Rezoning Transportation Analysis

Petition Number: 2023-033

From: Jake Carpenter, PE

Date	Description
7-26-23	First Review (IW)
08-24-23	Second Review (NK)
9-20-23	Third Review (NK)

EXISTING ZONING: CG
PROPOSED ZONING: MUDD-O

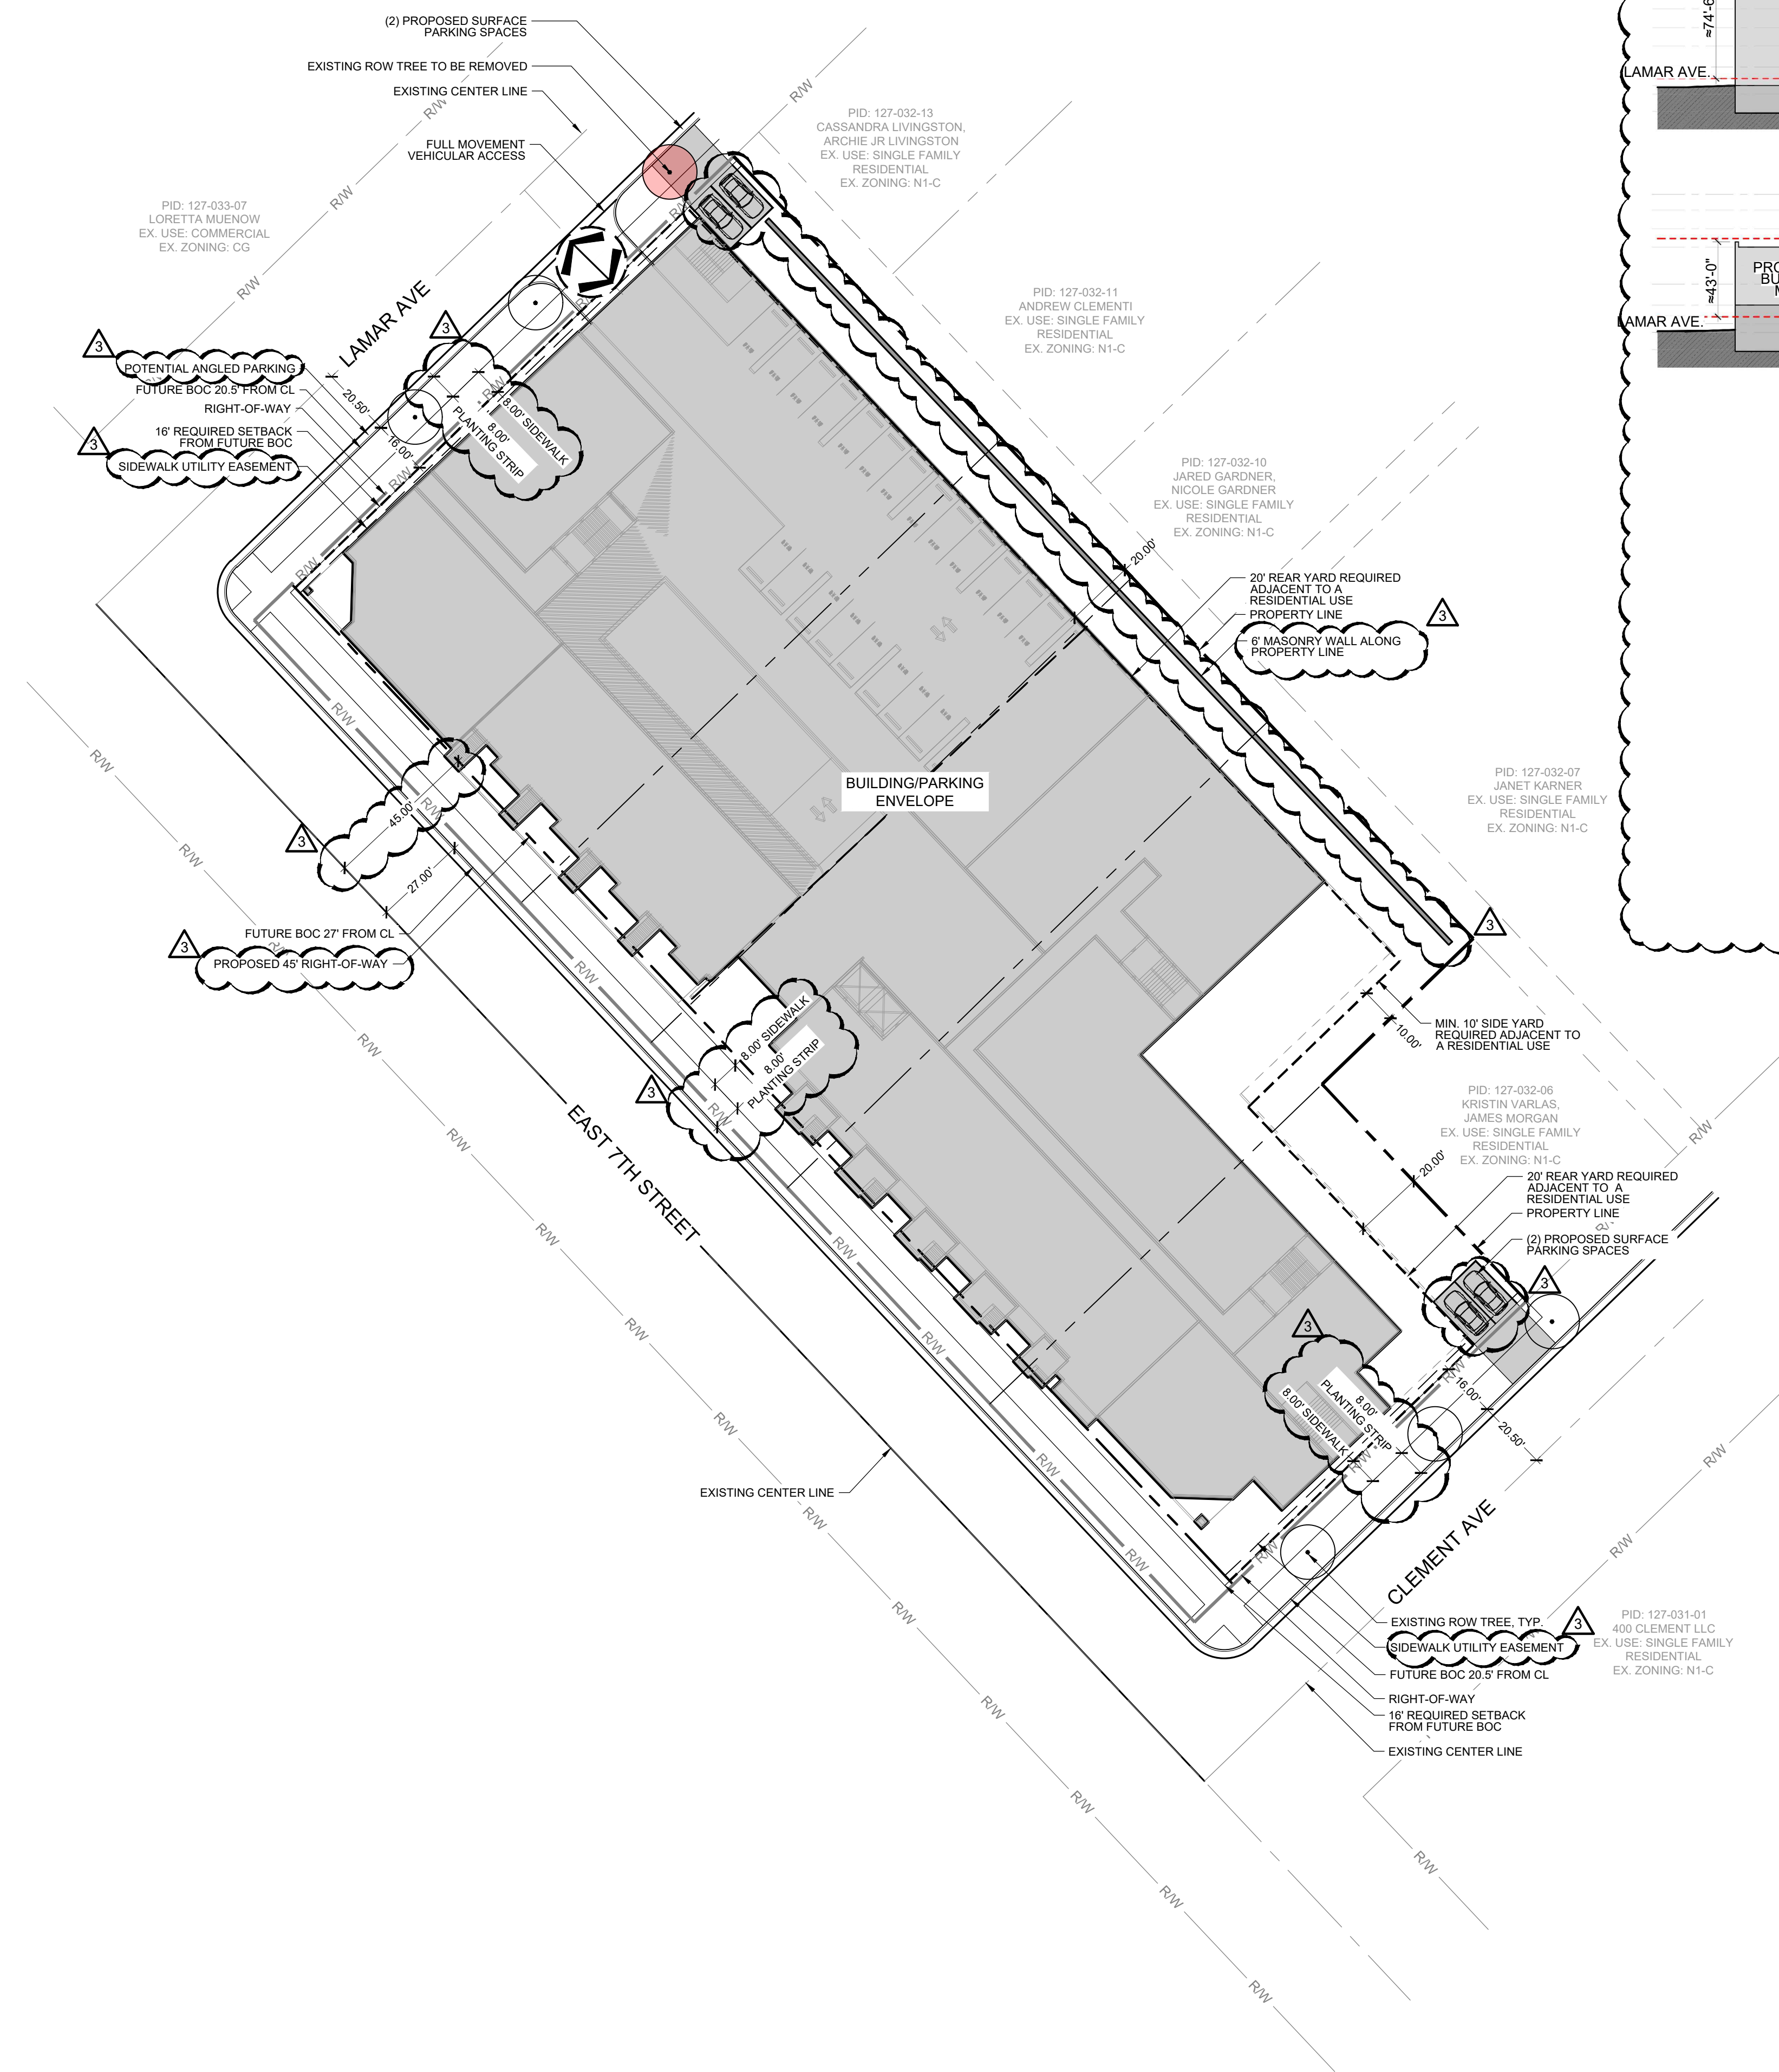
9. **Outstanding comment 7-26-23:** Provide additional information regarding Optional Provision II and requested maneuvering.

Clarifying Comment 8-24-23: It is unclear whether proposed parking spaces are encroaching on the required streetscape on Clement and Lamar Ave., provide additional clarification.

Clarifying Comment 9-20-23: Remove the additional parking spaces on Clement and Lamar Ave. Access to parking spaces is not allowed over a streetscape. This access would be considered a driveway and would be required to meet minimum driveway standards provided in the UDO and Charlotte Streets Manual, including geometric design, spacing, and internal stem requirements.

10. ~~Outstanding comment 7-26-23:~~ Add a conditional note specifying “the Petitioner shall dedicate and convey in fee simple all rights-of-way to the City before the site’s first building certificate of occupancy is issued. CDOT requests rights-of-way set at 2’ behind back-of-sidewalk where feasible.”

Clarifying Comment 8-24-23: Sidewalk must be located within ROW or a sidewalk utility easement, which must extend an additional 2 feet behind sidewalk. Site plan shall label and dimension ROW/SUE. If a sidewalk utility easement is utilized, include a conditional note regarding commitment to placing sidewalk within easement.

13. **New Comment 9-20-23:** Revise site plan to eliminate encroachment of building and building entrances into the right-of-way.
